Harnett County Government Complex
307 Cornelius Harnett Boulevard
Lillington, NC 27546

March 13, 2009

Re: Status of Improvement Permit Application #09-5-21655R

map #2004-15  
Taylor  
scale: 1/32"=1'

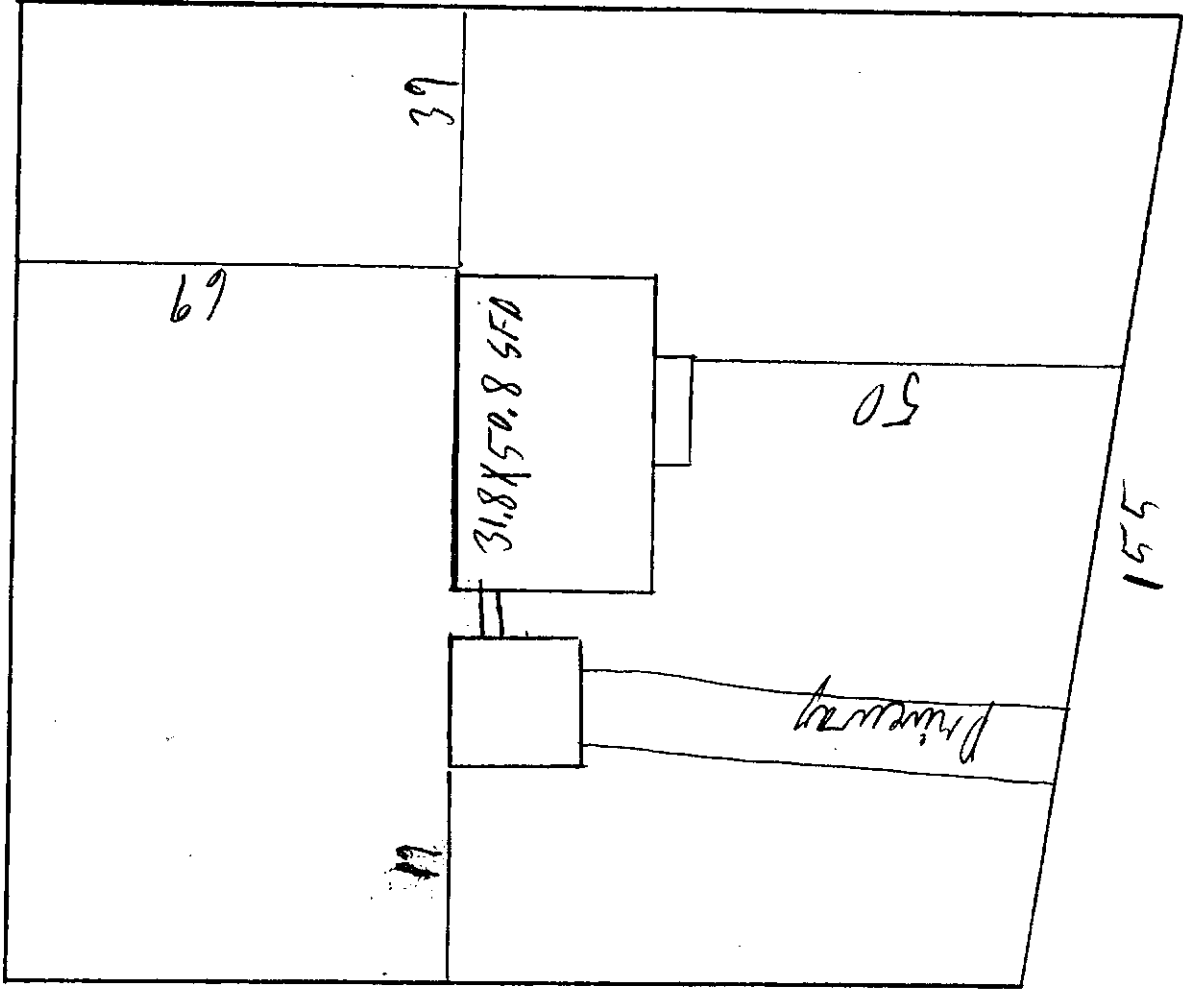
- 1. Property lines/corners not marked or labeled *(\$25.00 fee incurred)*
- 2. House corners not marked or labeled *(\$25.00 fee incurred)*
- 3. Directions not clear to property *(\$25.00 fee incurred)*
- 4. Property needs brush or vegetation removed
- 5. Backhoe pits required
- 6. Other – Revise site plan to show front property line setback of 43 feet.
